**Consultation Response from KC,
Highways Development Management**

2025/91639 40, Bradford Road, Fartown, Huddersfield, HD1 6JE

Erection of 3 storey extension and alterations to form student accommodation

Date Responded: 28-7-2025.

Proposed block plans
Scale: 1/500

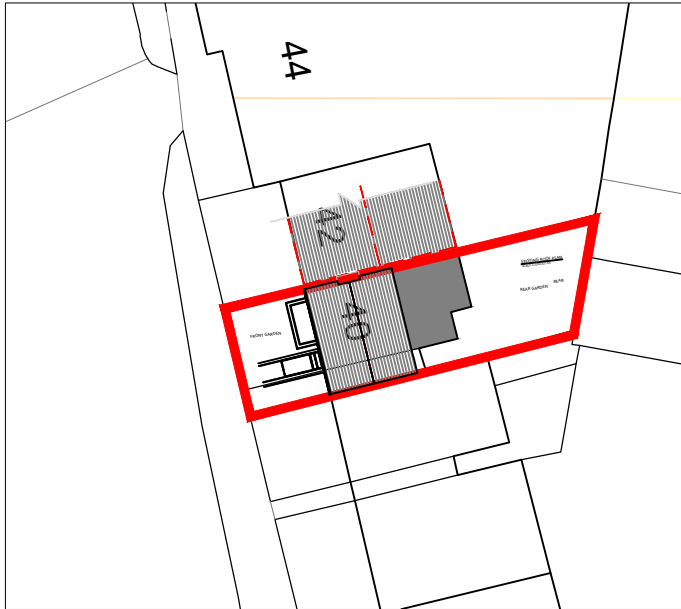
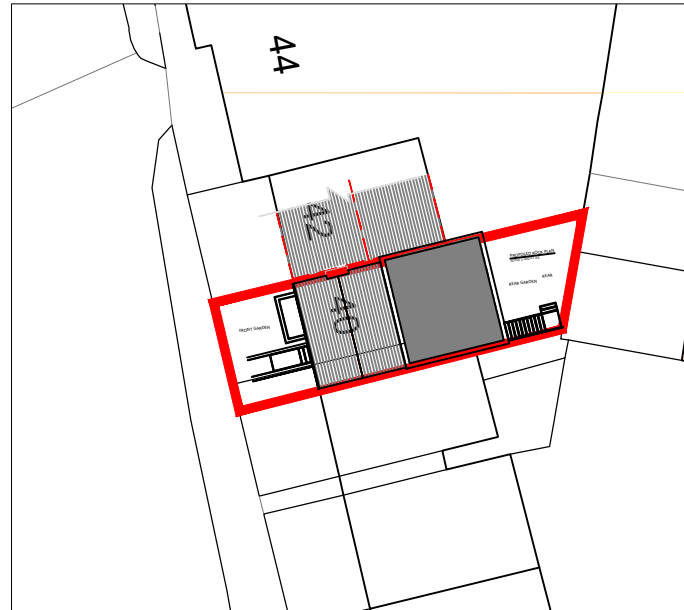
No details of the storage and collection of waste are provided. HDM would not wish to see bins stored or left on the Bradford Road footway for collection.
